Lime Down

Solar Park

Volume 3, Appendix 8-5: Landscape

Consultation Record

Title:
Figure 4-4: Main Infrastructure Layout Changes between PEIR and DCO Application

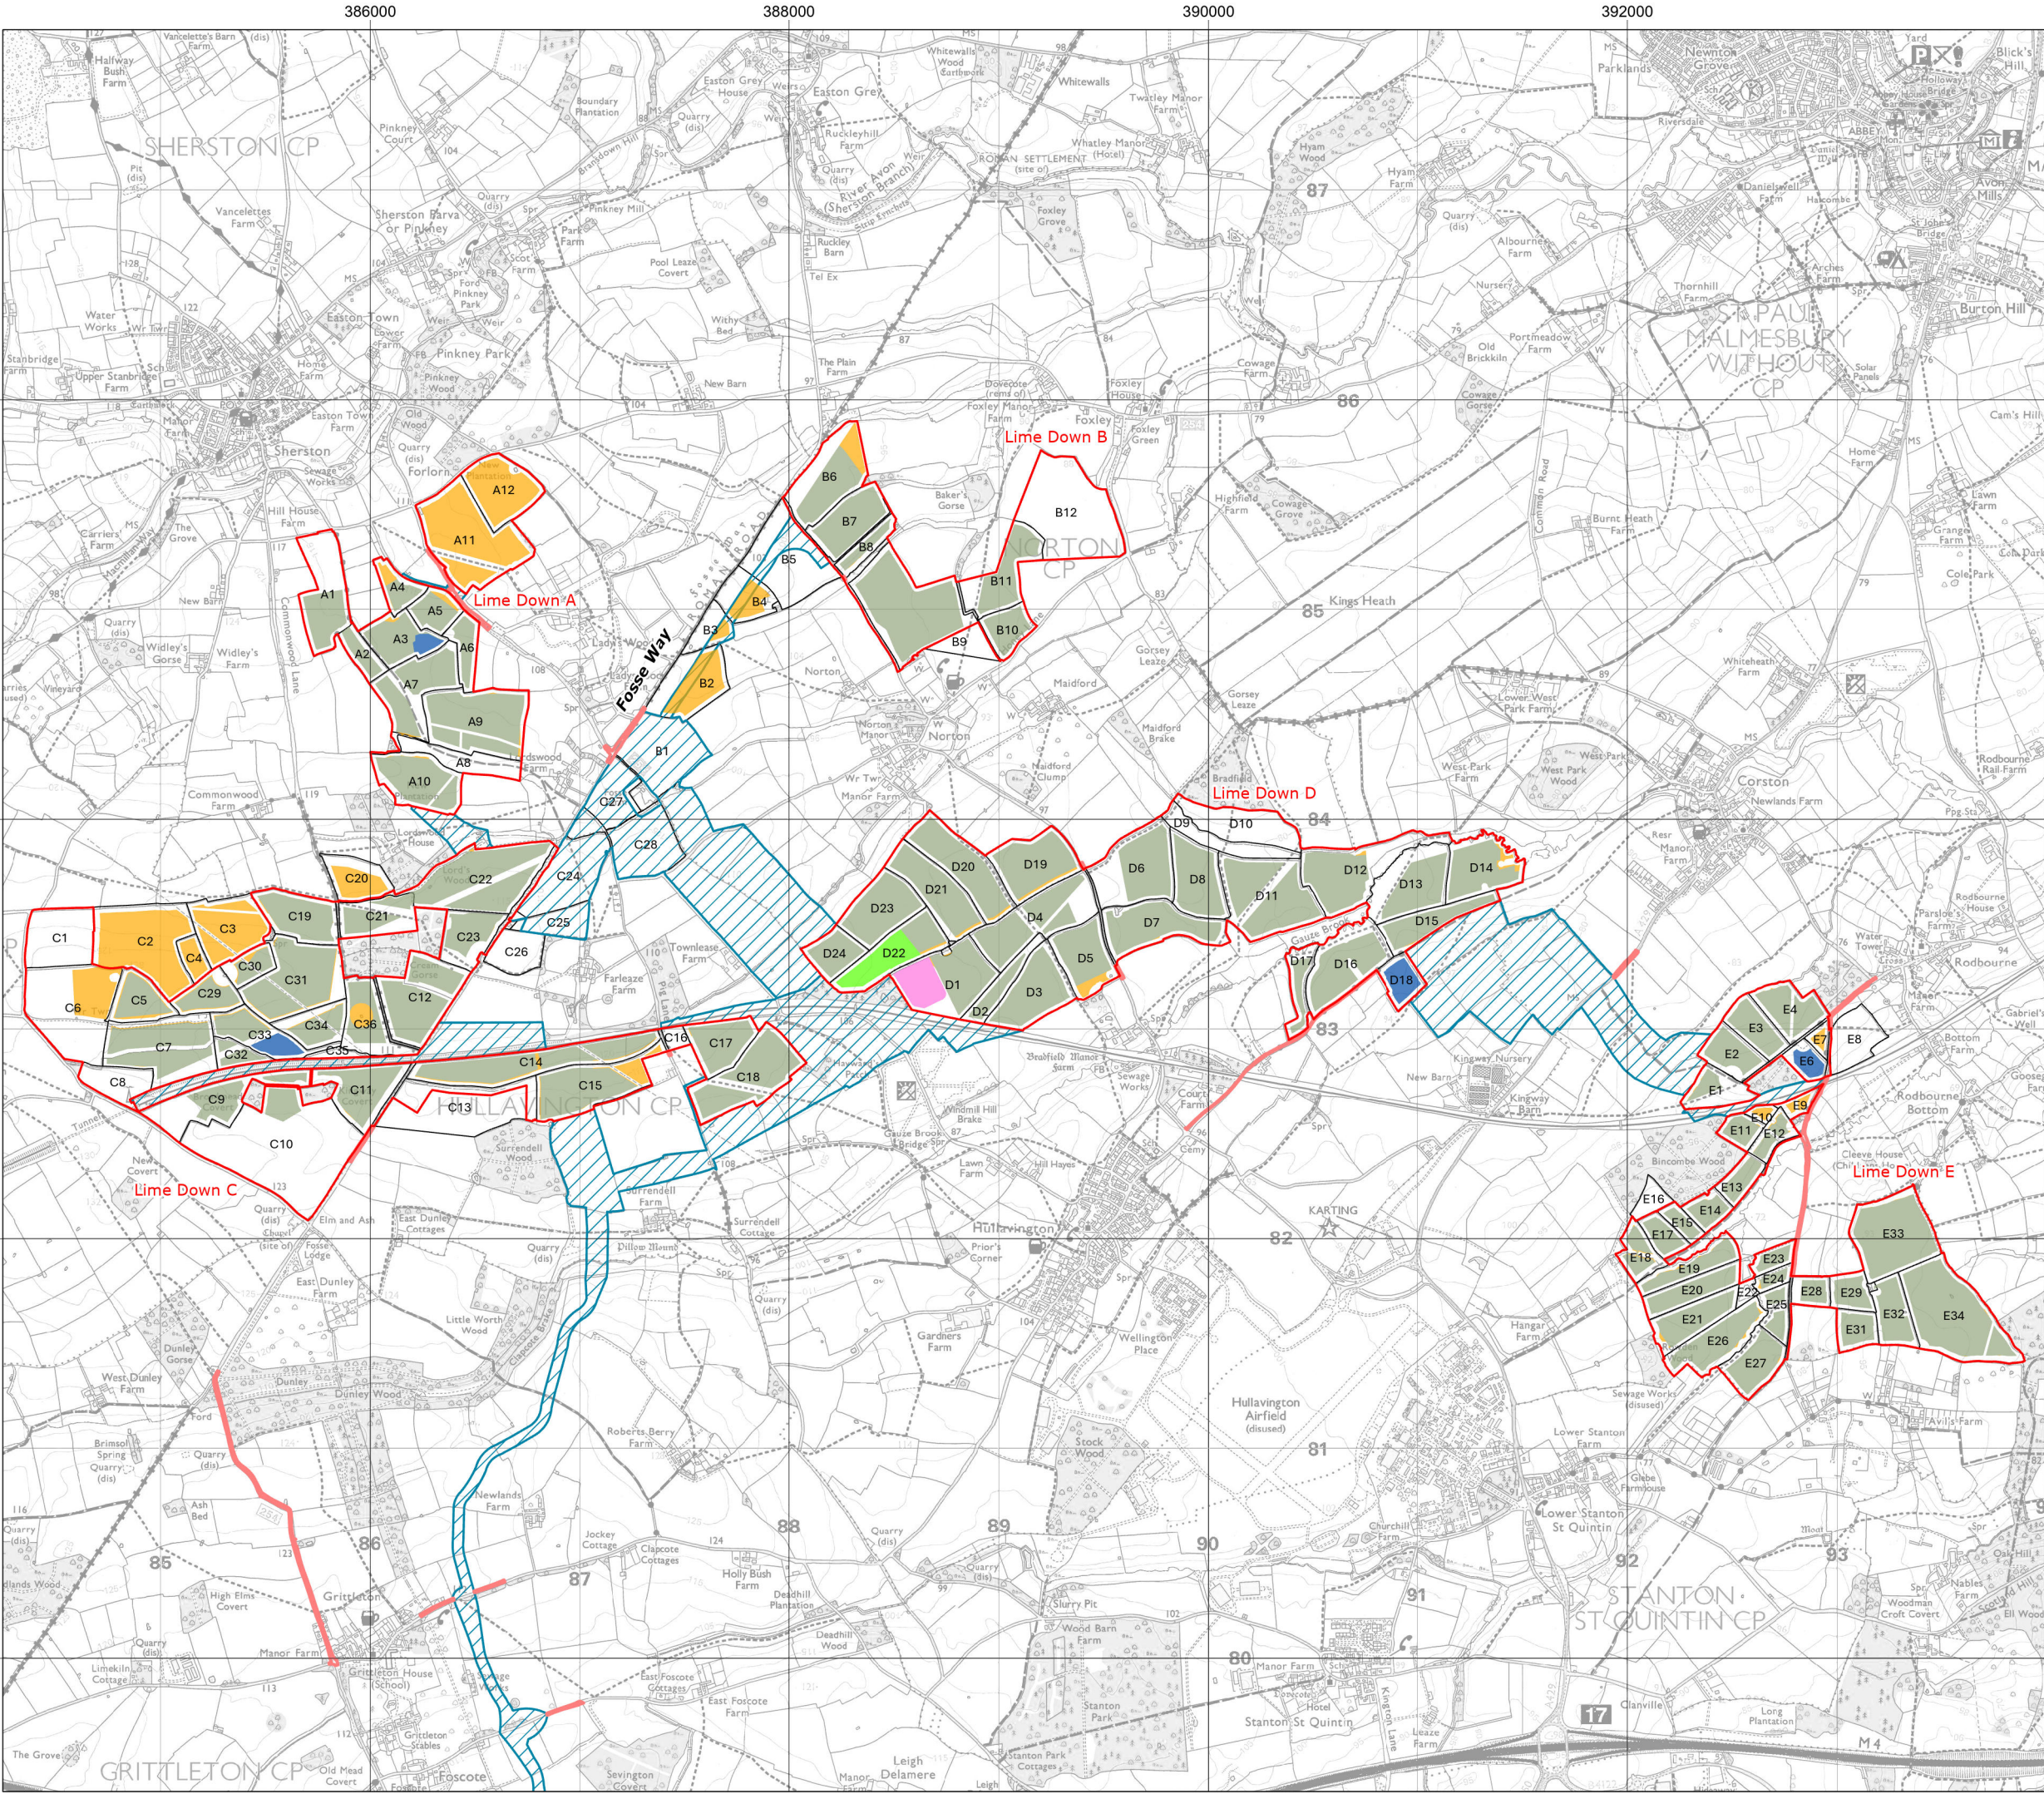
Council Name	Feedback	LVIA Response
	panels were removed only from field A12, panels within field A11 would remain highly visible from PVP3 as well as from the road as it travels westwards along the northern boundary of A12 which marks the CNL boundary.CNLB Recommendation: Remove all panels from both fields A11 and A12 and identify these fields for habitat enhancement."	
Cotswolds National Landscape	<p>"Lime Down A</p> <p>Receptor: TP027: Footpath WT SHER 15</p> <p>PVP: CNL C</p> <p>PEIR assessed visual effect at Construction (C)/Y1/Y15/Decommissioning (D). Bold denotes a significant effect in EIA terms:</p> <p>C. Major/moderate adverse</p> <p>Y1. Major/moderate adverse</p> <p>Y15 Moderate adverse</p> <p>D. Minor adverse</p> <p>CNLB comments: This footpath passes through field A11 and provides views towards the CNL, the boundary of which is marked by the road running along the northern edge of the field. Some views of the church tower at Sherston (within the CNL) are possible when walking northwest.</p> <p>The indicative masterplan shows the footpath would be retained within a corridor with 4.5m solar panels on both sides. Views to the CNL and the church tower would be lost from construction onwards.</p> <p>We agree with the assessment of significant adverse effects from construction to the end of operation.</p>	<p>Noted.</p> <p>Assessment reviewed as panels in A11 and A12 are removed.</p>

Council Name	Feedback	LVIA Response
	Possible removal of panels from the southern half of A1 pending the results of further assessment"	
Cotswolds National Landscape	"Lime Down CReceptor: TP077 Footpath WT LUCK 35PVP: 27, 30, 31PEIR assessed visual effect at Construction (C)/Y1/Y15/Decommissioning (D). Bold denotes a significant effect in EIA terms: C. Major adverseY1. Major adverseY15 Moderate adverseD. Moderate adverseCNLB comments: This footpath lies within the CNL to the west of the road between Sherston and Alderton and with clear views to the CNL (including the church tower at Alderton) for much of the stretch outside of the CNL between that road, passing viewpoint 30 and onto viewpoint 27 on Commonwood Lane. As such we agree with the assessed high receptor value, susceptibility and sensitivity. We support the exclusion of field C1 for habitat enhancement. However, panels would still be clearly visible for much of this stretch in fields C2, C3, C4 and C19, either from viewpoints within the CNL or when outside the CNL looking back towards the CNL and in some cases blocking the view of the church tower. Proposed mitigation along the field boundaries would not adequately screen views of the 4.5m panels which would create skyline effects for much of the stretch. We agree that there would be a major adverse effect on this receptor at construction and year 1, however disagree that by year 15 mitigation planting will have predominately screened views of the development and that the significance of effect would remain at least major/moderate.CNLB Recommendations: Remove all panels from fields C2, C3 and C4 on the northern side of the ridge running through the field or in areas where skyline effects would be apparent and identify these fields for habitat enhancement."	Noted. Assessment reviewed as panels in C2 C3 and C4 are removed.

Council Name	Feedback	LVIA Response
	<p>PEIR assessed visual effect at Construction (C)/Y1/Y15/Decommissioning (D). Bold denotes a significant effect in EIA terms:</p> <p>C. Moderate adverse Y1. Moderate adverse Y15 Minor neutral D. No effect</p> <p>CNLB comments: Rural road between Sherston and Alderton on the boundary of the Cotswold National Landscape. At the southern end of the road there are views south towards the church at Alderton beyond large arable fields punctuated by mature trees.</p> <p>We agree that receptor value should be high and susceptibility is medium, resulting in a high-medium sensitivity.</p> <p>Although no panels are proposed in field C1, fields C2, C3 and potentially C4 would be visible and due to the rising topography of these fields and elevated position of the viewpoint around Widleys Farm, we consider that mitigation planting would have a limited effect in screening the panels. Remove all panels from fields C2, C3 and C4 on the northern side of the ridge running through the field or in areas where skyline effects would be apparent and identify these fields for habitat enhancement.</p> <p>We agree that there would be a significant adverse effect at construction and year 1.</p> <p>We also consider that it may be possible on the stretch by Widleys Farm to see both Lime Down A and Lime Down C, resulting in a degree of cumulative effect.</p> <p>CNLB Recommendations: Remove all panels from fields C2, C3 and C4 on the northern side of the ridge running through the field or</p>

Council Name	Feedback	LVIA Response
	<p>regarding embedded mitigation measures outlined at Section 8.8, where a mitigation hierarchy of i) prevent/avoid, ii) mitigate and restore and finally iii) offset, or failing that, iv) compensate is used to reduce development impacts and control any negative effects on the environment.</p> <p>In particular, we note the recommendation at paragraph 8.8.4 that “avoidance measures are incorporated into the design of the scheme in order to reduce development impacts and control any negative effects on the landscape, especially on sensitive receptors such as the Cotswolds National Landscape. These measures include avoiding development adjacent to the National Landscape where it would affect its setting; and avoiding development where it would be visually intrusive and affect the character and visual experience of the landscape”.</p>	
Cotswolds National Landscape	<p>"Lime Down A</p> <p>Receptor: TP026: Footpath WT SHER 12</p> <p>PVP: 4</p> <p>PEIR assessed visual effect at Construction (C)/Y1/Y15/Decommissioning (D). Bold denotes a significant effect in EIA terms: C. Moderate adverse Y1.Moderate adverse Y15 Moderate/minor adverse D. No effect</p> <p>CNLB comments: We agree with the assessment contained within Volume 3, Appendix 8.3.2.3 that receptors on this footpath within the CNL are classified as high in terms of value, susceptibility and sensitivity.</p> <p>However, we disagree that the magnitude of change resulting from the introduction of panels into fields A11 and A12 would be low at</p>	<p>Noted. Assessment has been reviewed as panels in A11 and A12 are removed.</p>

Council Name	Feedback	LVIA Response
	<p>construction and year 1, reducing to very low by year 15.</p> <p>The AVR 1 visualisations, in particular Figure 8-14-4, illustrate that the 4.5m high rotating panels would be highly visible in views along this footpath (a promoted route, the White Walls Way) and mitigative planting would be unlikely to screen views as suggested, even by year 15 due to the elevated position of this viewpoint.</p> <p>We consider that the proposal would result in a medium magnitude of effect at construction and year 1 and resultantly a major/moderate adverse significance of visual effect. It would be unlikely to reduce to a level which was not significant by year 15.</p> <p>CNLB recommendation: Remove all panels from both fields A11 and A12 and identify these fields for habitat enhancement"</p>	
Cotswolds National Landscape	<p>"Lime Down AReceptor: TR044: Bridleway WT SHER 14PVP: 3PEIR assessed visual effect at Construction (C)/Y1/Y15/Decommissioning (D). Bold denotes a significant effect in EIA terms: C. Major/Moderate adverseY1. Major/Moderate adverseY15 MinorD. No effectCNLB comments: This is a long section of road from near Sherston towards Foxley on the boundary to the Cotswold National Landscape. We note that there is no separate assessment for bridleway SHER14 which joins this road at PVP3, on the CNL boundary. We agree that receptor value should be high and susceptibility is medium, resulting in a high-medium sensitivity. The AVR 1 visualisations at Figure 8-14-3, illustrate the potential height of the panels and how visible they would be from PVP3 and when travelling both east-west along the road and north-south along the bridleway. As such we agree with the assessment of a major/moderate adverse significance of effect at construction and year 1. However, we disagree that the mitigation planting would screen views to an extent where the magnitude of change and type of effect would be reduced from high/adverse at year 1 to very low/neutral by year 15. We consider it likely that there would remain at least a moderate adverse significance of effect at year 15. If</p>	Noted. Assessment reviewed as panels in A11 and A12 are removed.

Cotswolds National Landscape	"Lime Down C Receptor: TR040 Road from Alderton to Sherston past Widleys Farm PVP: WC1	Noted. Assessment reviewed as panels in C2 C3 and C4 are removed.
